# Site Development Plan

# Site Development Plan\_V1.pdf Markup Summary

Brewery/Tasting Room SDP Cover Sheet

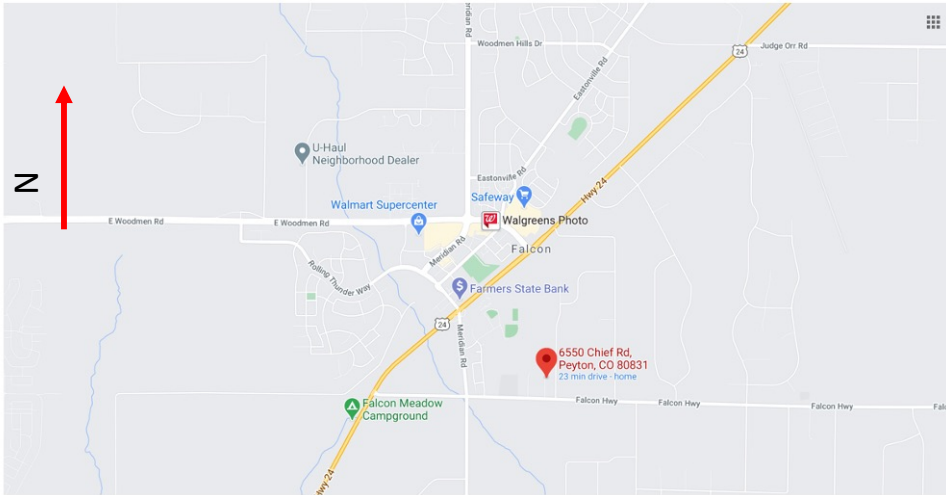
Staff recommends the addition of a cover sheet that should include general notes and contact information. Make sure it has an appropriate title, vicinity map, and room for County signatures. Add PCD File No. PPR-2247 to title sheet as well.

Add vicinity map showing the subdivision in relation to section lines and existing or proposed arterial or collector roadways.

Site Development Plan

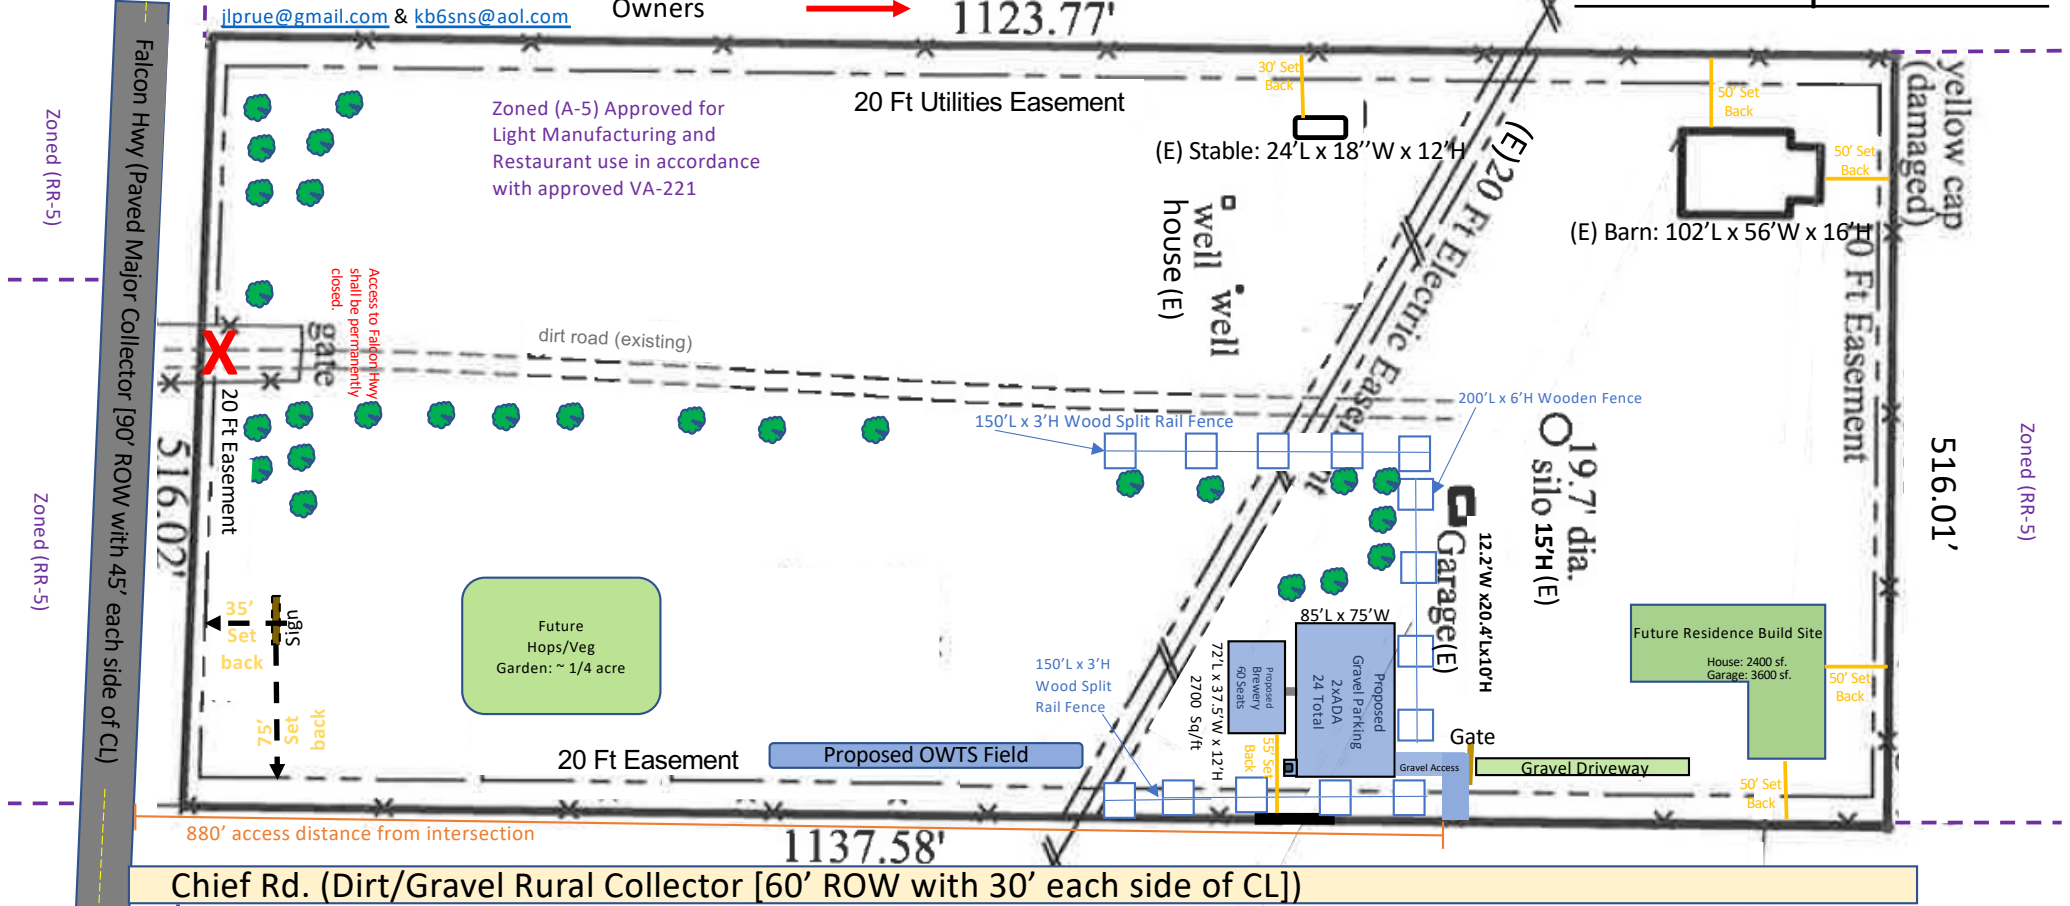
Please location of all existing and proposed utility lines and associated infrastructure

Please confirm easement 20' or 30'?

Add a note that states access to Falcon Highway shall be closed off permanently.

Label existing

Show proposed land disturbance on the site plan.

Note: except for the driveway, any impervious areas shall drain towards the site and not towards Chief Road.

Label distance of access from Falcon Highway and Chief Road intersection.

Provide a scaled drawing.

Site Development Plan

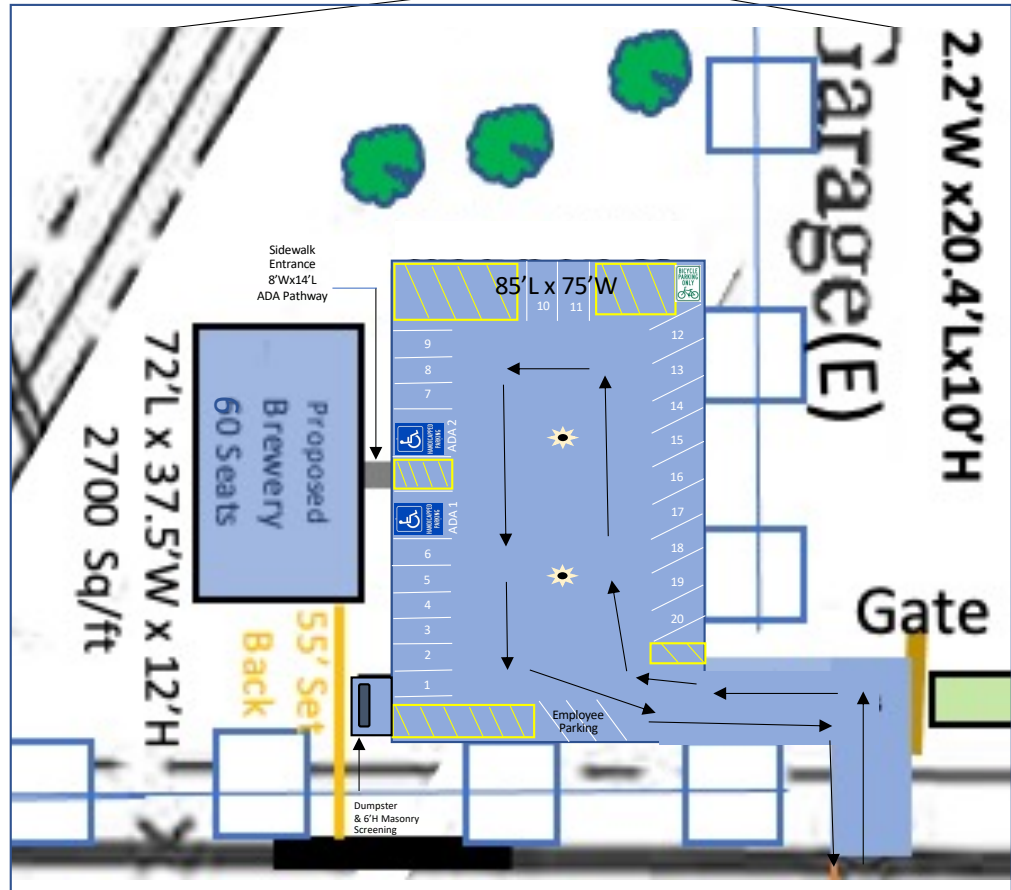
Specify ADA pathway

Provide depiction of dumpster screening
